CITY OF ALBUQUERQUE

September 03, 2013

**Re: Caliber's Shooting Range, 4340 Cutler Ave. NE
Request For Permanent C.O.
Engineer's Stamp Dated: 02-05-13 (H17/D089A)
Certification dated: 08-30-13**

PHASE 2 GRADING PLAN

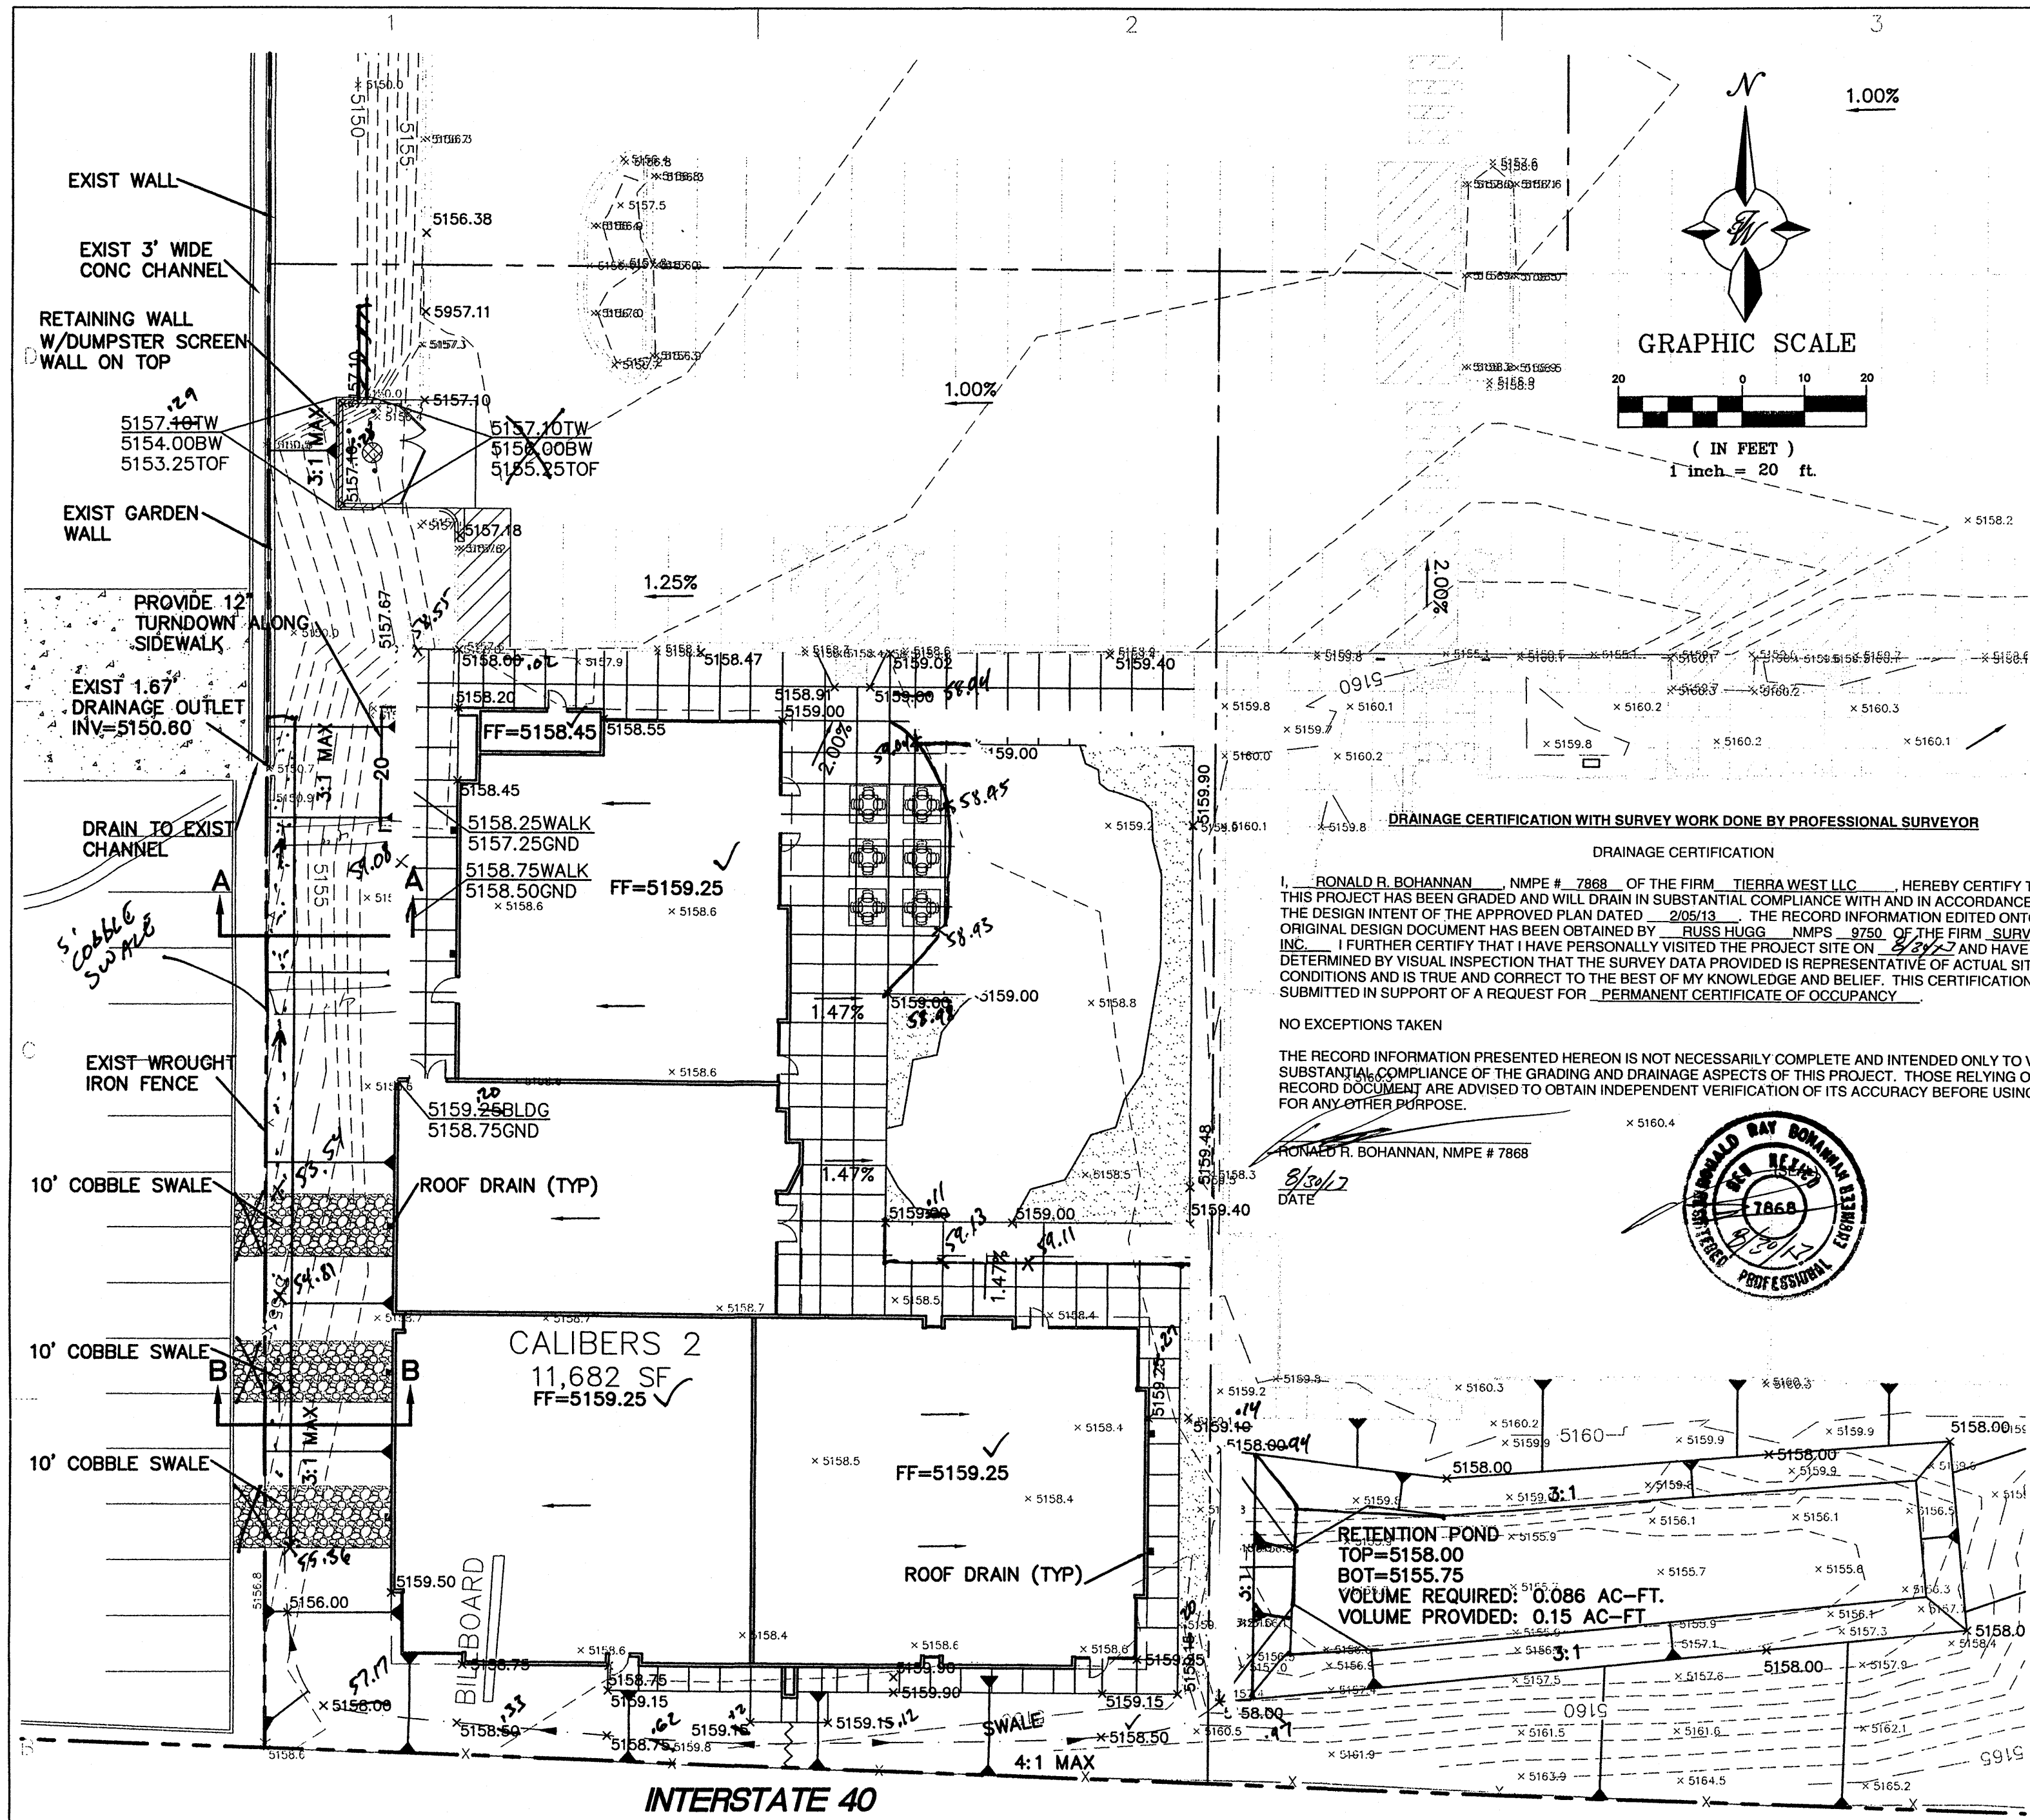
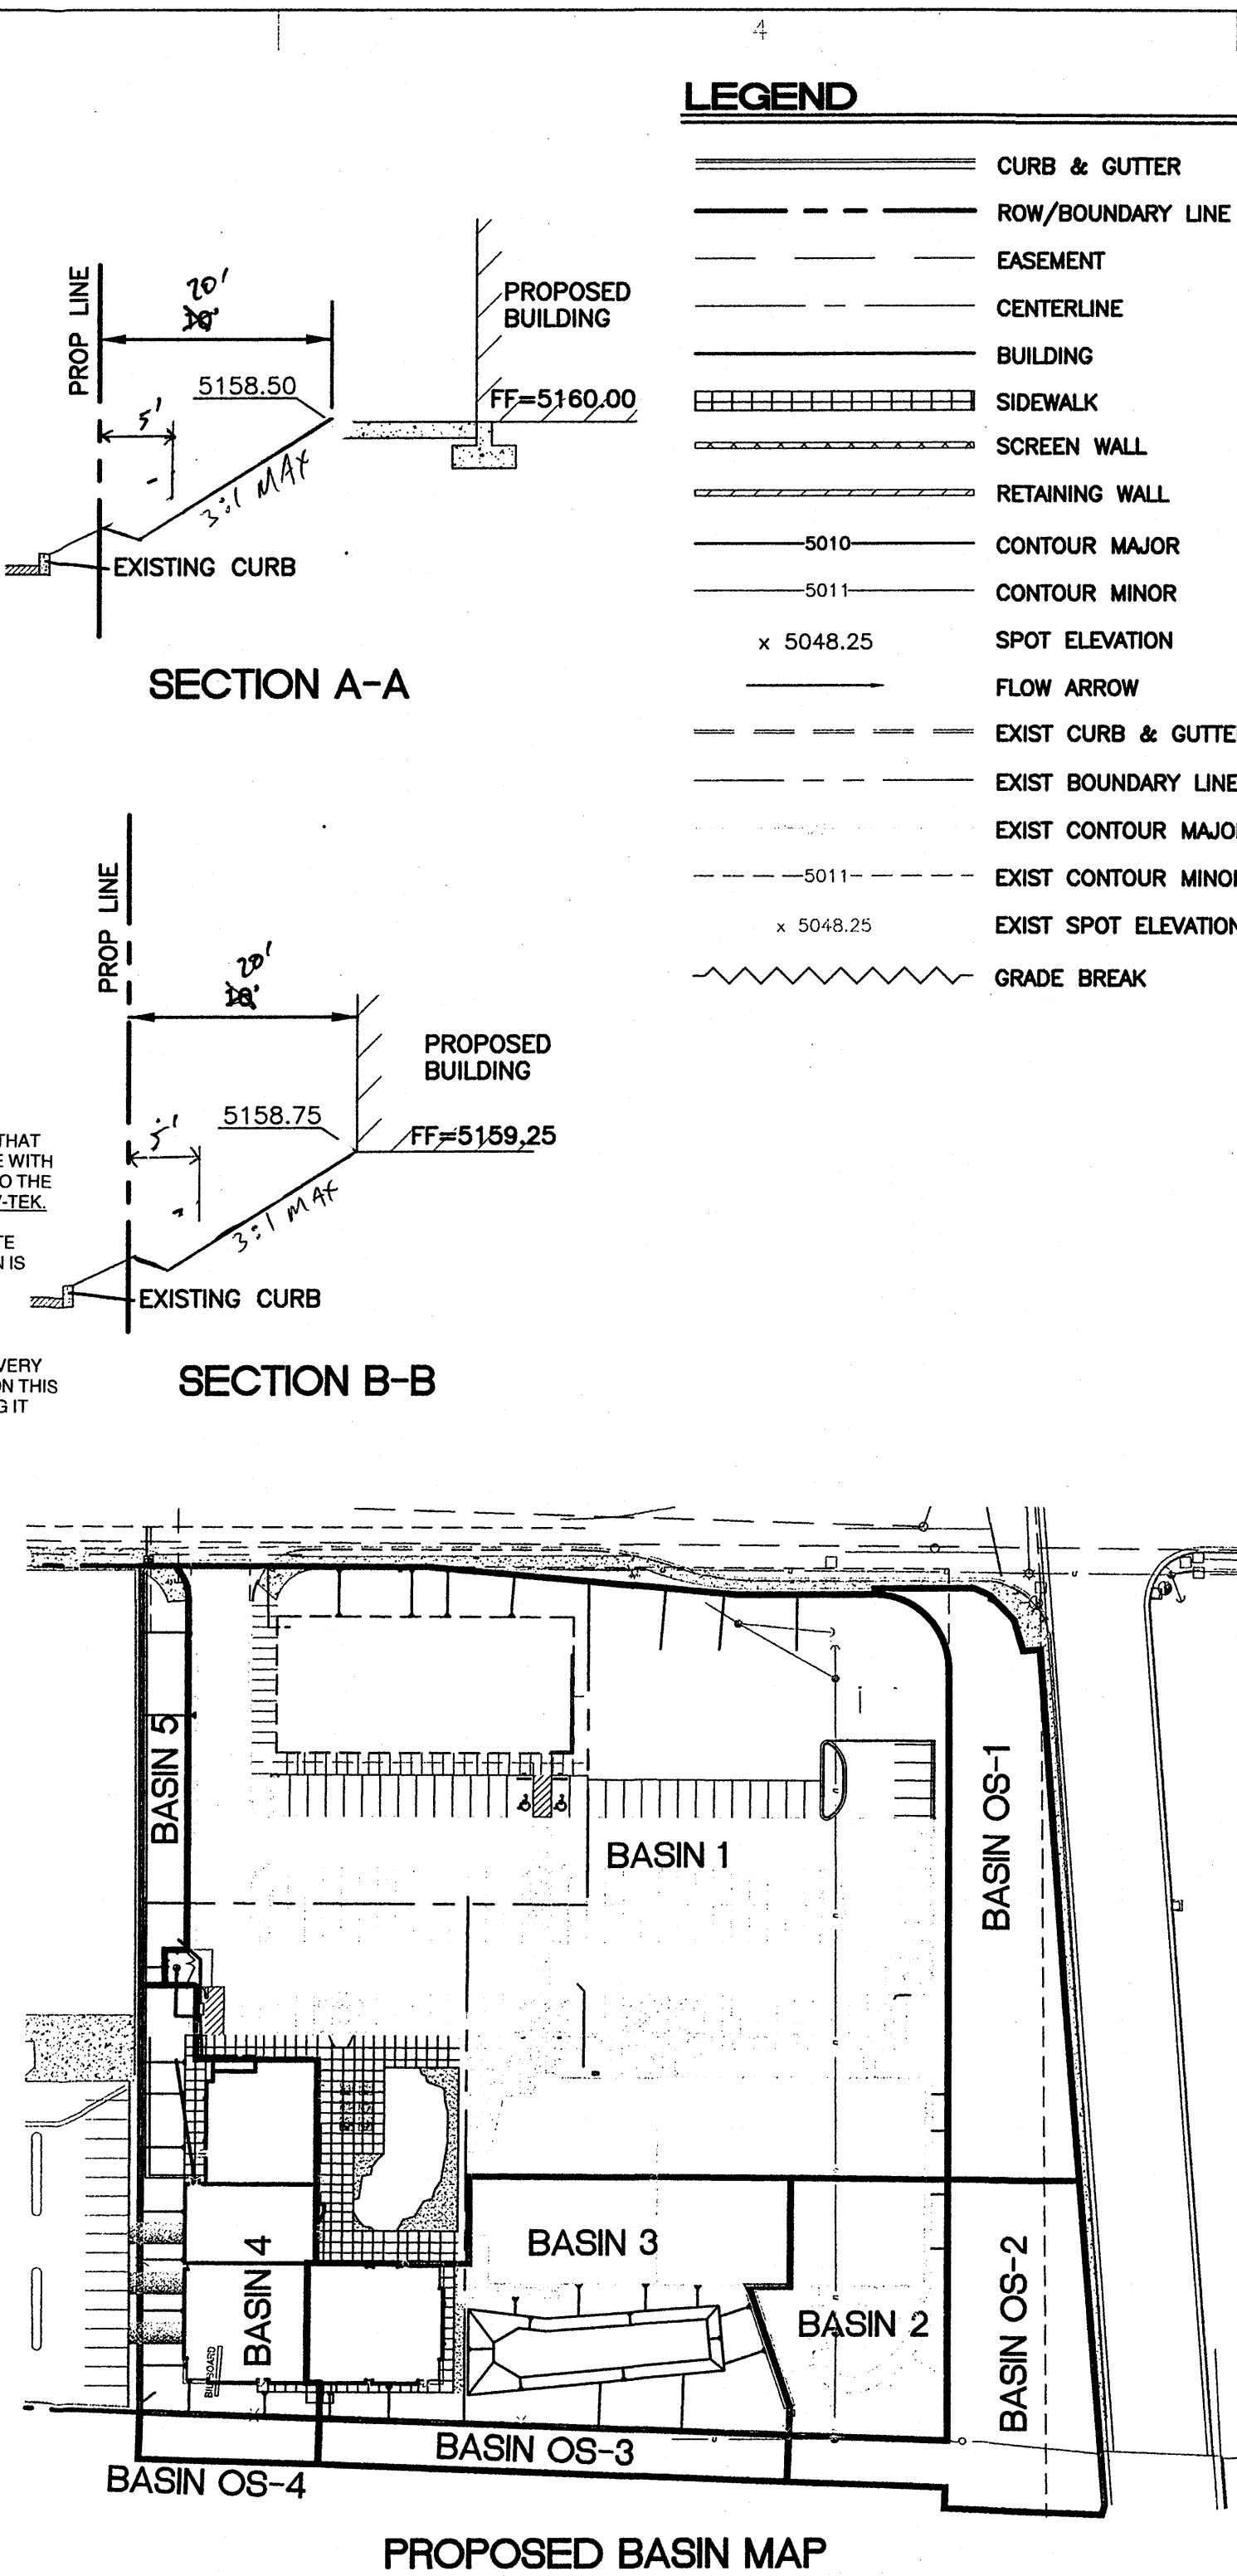
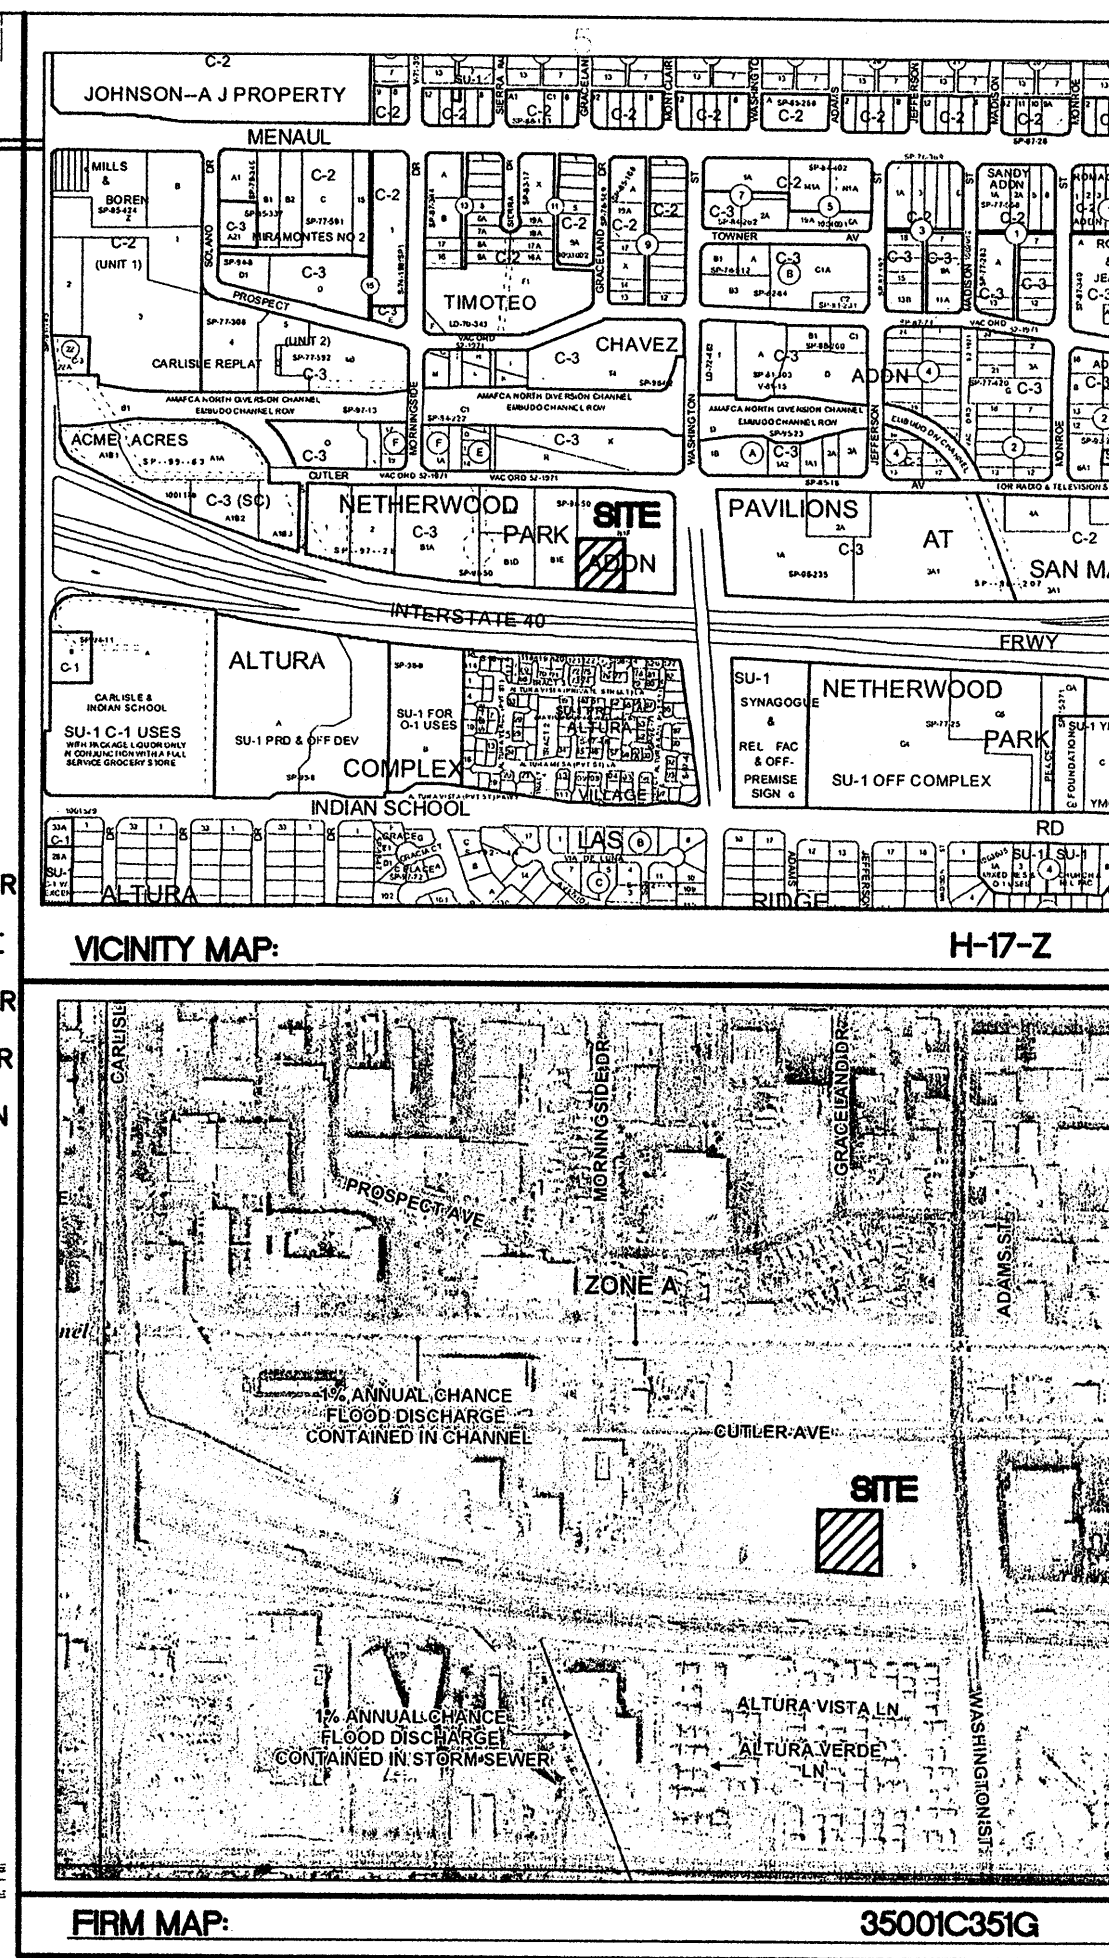
- Add large cobbles, from the discharge point of the two most northerly roof drainage pipes to the bottom of the slope, on the west side of the building.
